Our Ref: PO230B 17-10-2023

**RE:   Application Ref: 2023/91261**  
**Land at Alexandra Road West, Paddock**

Further to our earlier objections to the aforementioned application, we are aware that the Applicant has now submitted additional plans and details in relation to the swept path analysis for vehicles entering and exiting the site, alongside site sections and site plans.

Drawing Title  
**Proposed Site Plans**

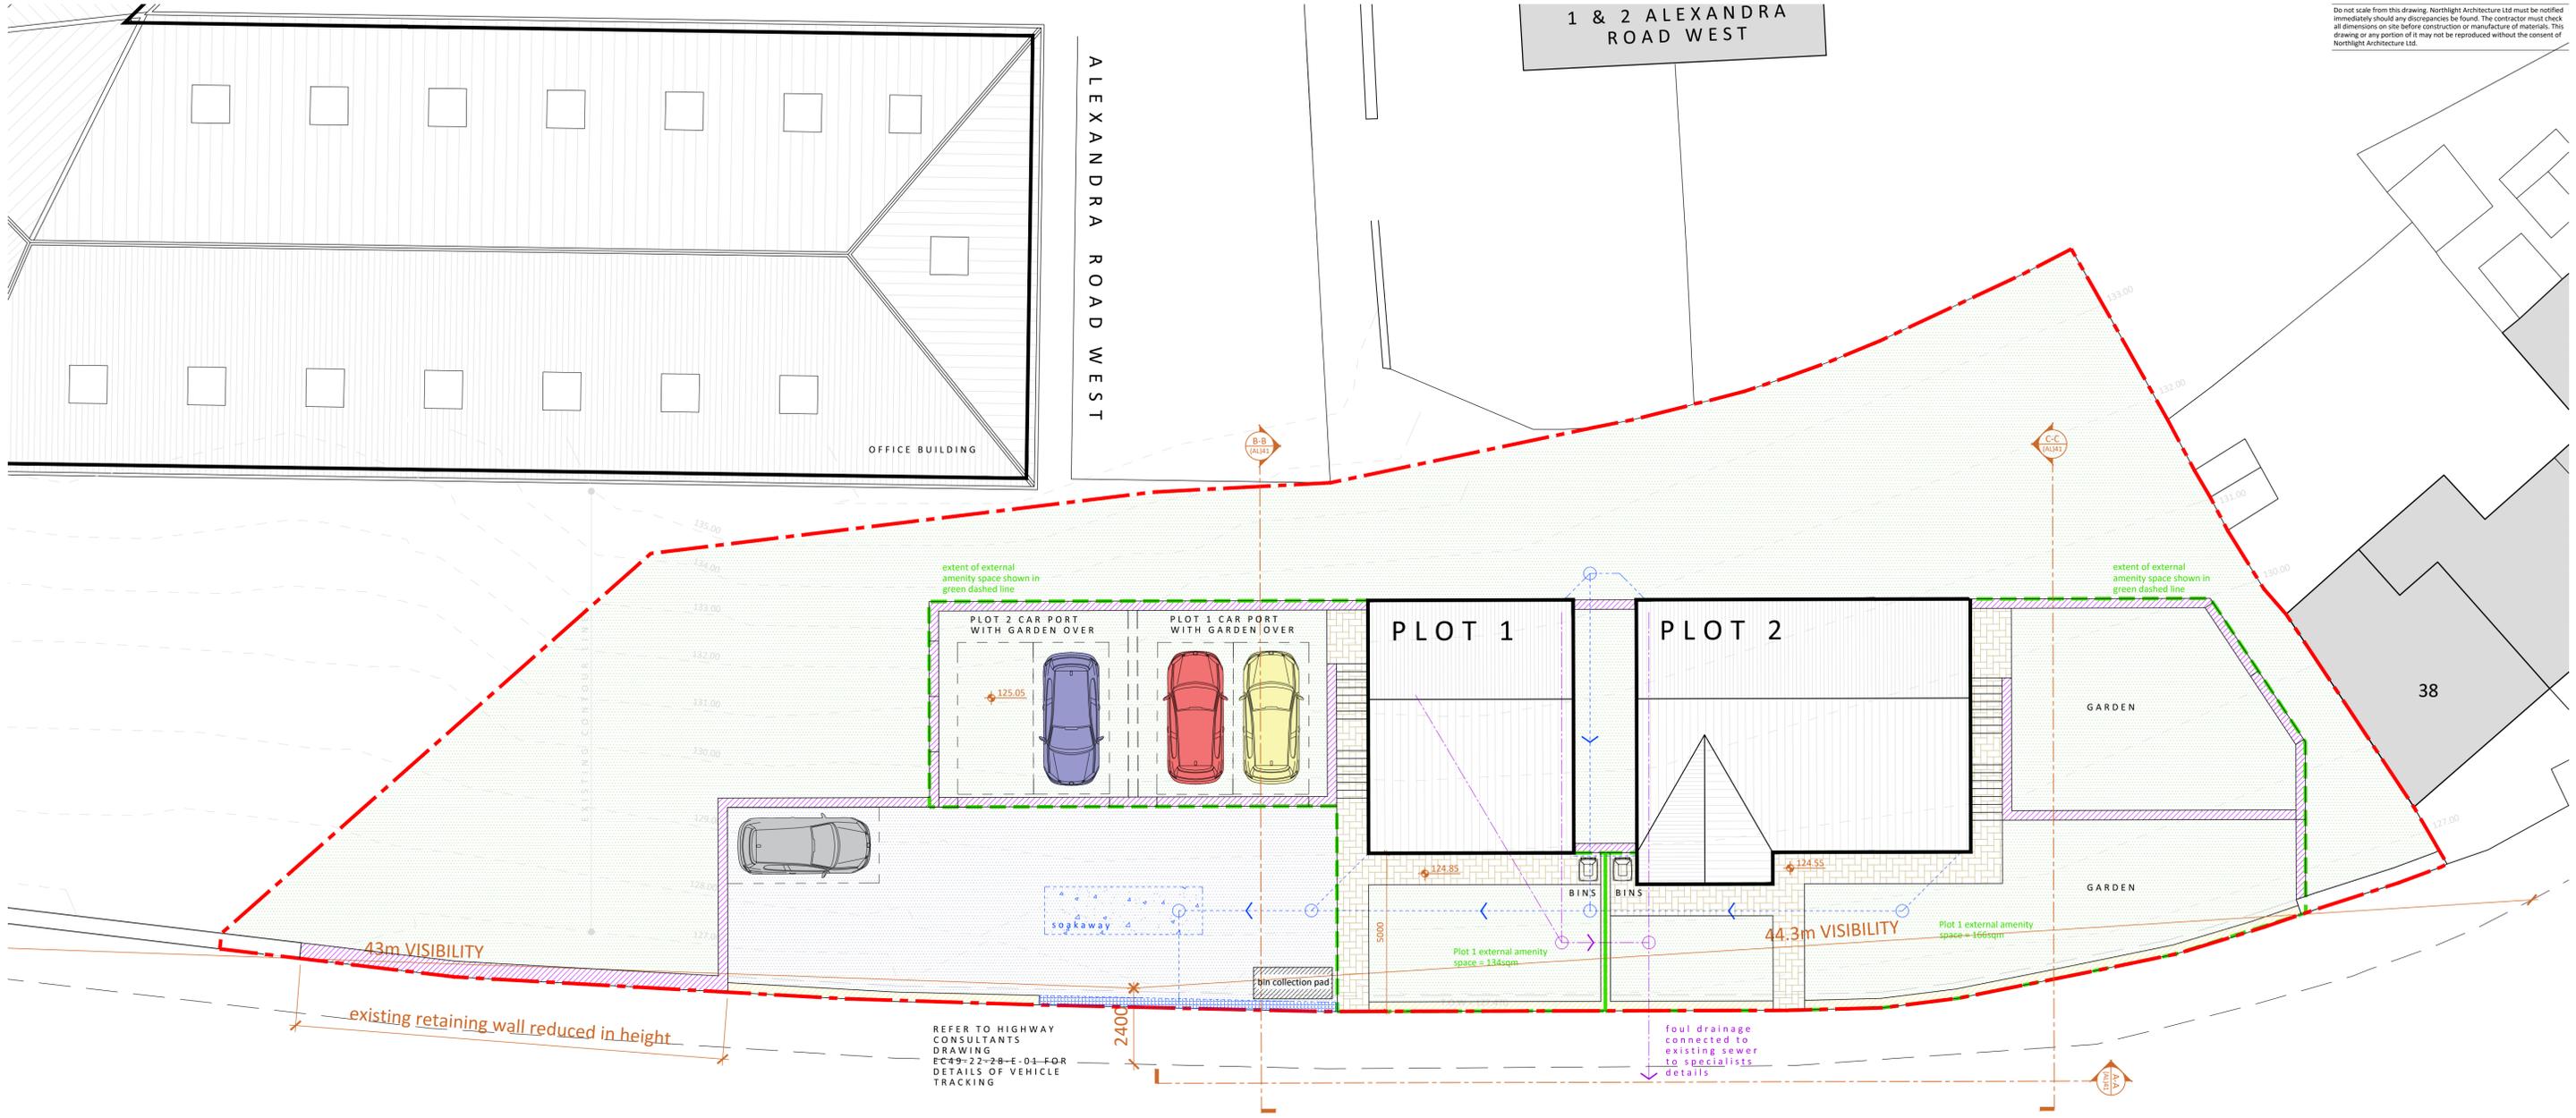
It is noted that the proposed bin storage pad shown on the proposed site plan has also not been included on the swept path plans, and there would appear to be some infringement from vehicle movements into this area. In our view the bin storage space should have been shown on the plans to ensure that vehicles can manoeuvre within the site, within the actual space available. Without confirmation of the same, it cannot be shown that the development is acceptable.

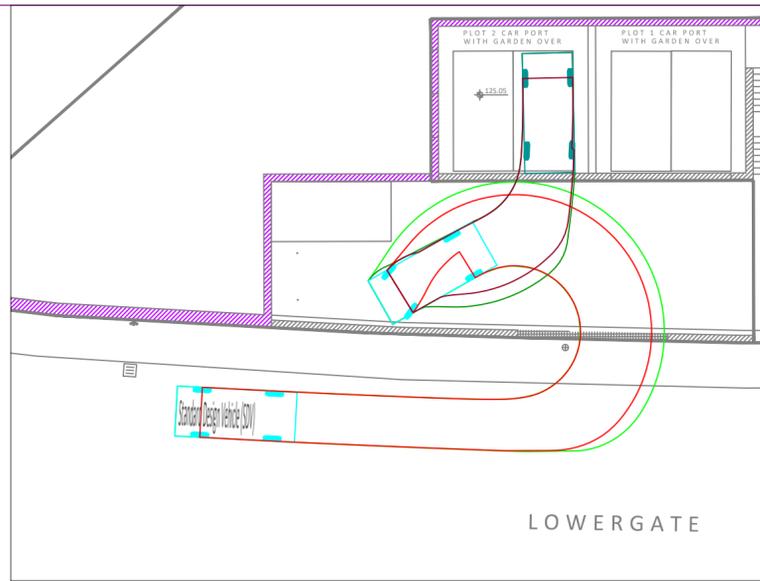
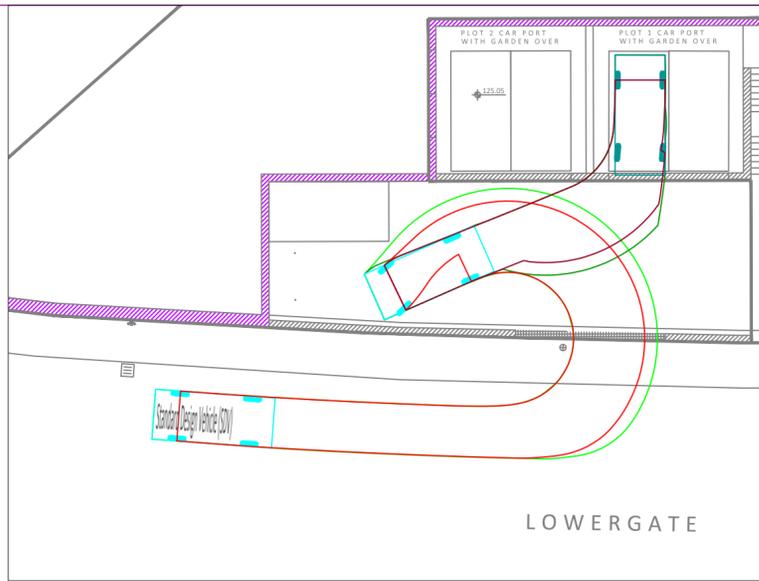
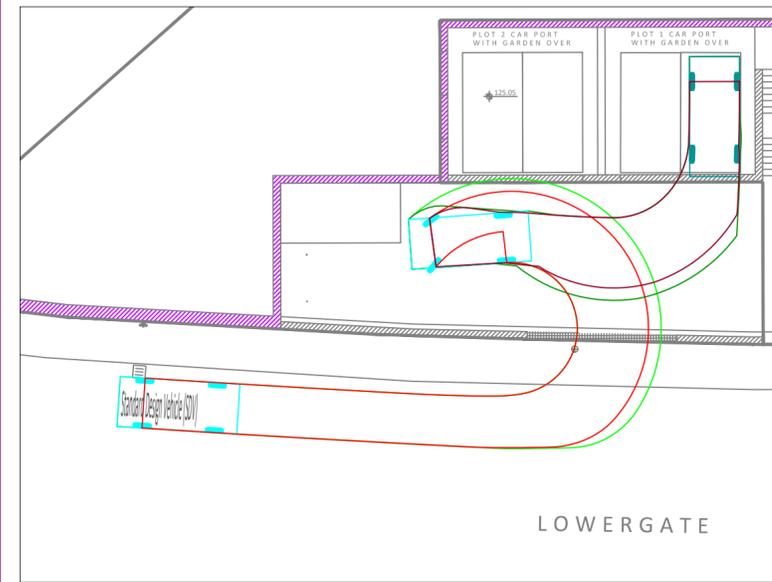
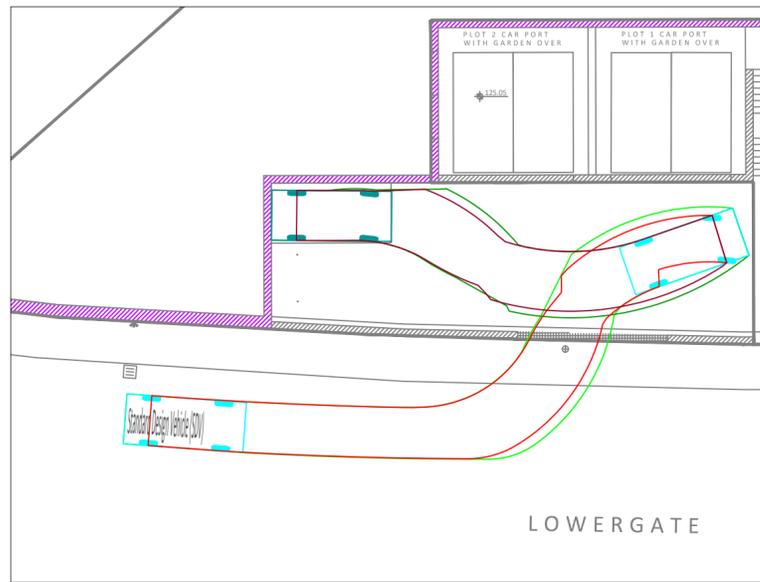
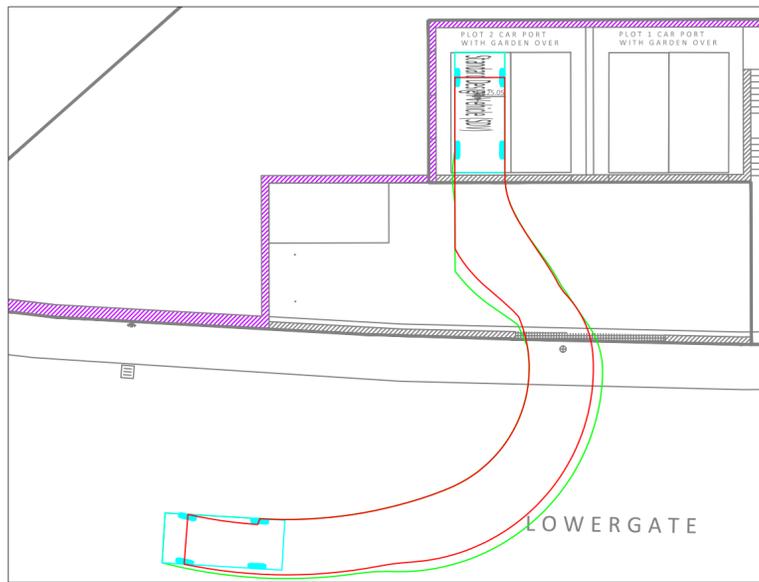
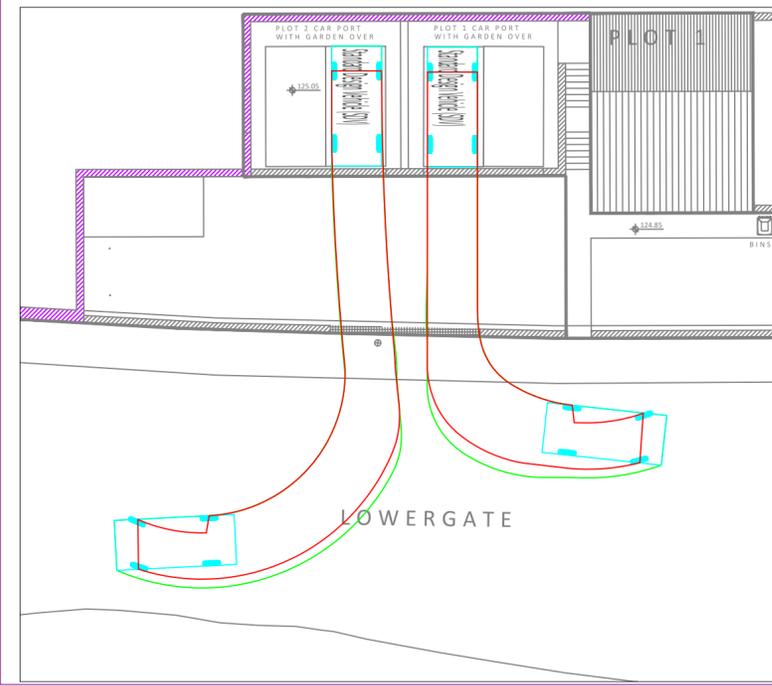
It is noted that the plans only relate to the use and accessibility of the site for one standard car. No analysis appears to have been undertaken of a larger vehicle, and it is unclear whether the analysis accurately reflects accessibility for as example for an SUV? Given that day to day cars are now substantially larger than historically, this should be clarified. In any event, whilst the plans appear to indicate the ability to access each space, this accessibility is shown to be incredibly tight, with some manoeuvres taking vehicles practicably up to boundary walls, and within the car port frontages to manoeuvre. There is a clear lack of internal manoeuvring space within the site boundary to service the development.

The plans do not provide any clarity as to accessibility should vehicles be parked within the site and not perfectly within an allocated bay. There is no allowance for bin wagons, delivery trucks/vans (who will inevitably drive into the site in a forward gear and reverse off site when

the delivery has been completed), ambulances etc, and no allowance for the realities of day to day living with general family paraphernalia in the circulation space, visitors parking outside of allocated spaces etc. In our view, the plans only demonstrate what could potentially be achieved in a perfect scenario, which will not reflect reality. Even then a number of the manoeuvres only further highlight how tight the site is, and the unacceptable level of development being proposed.
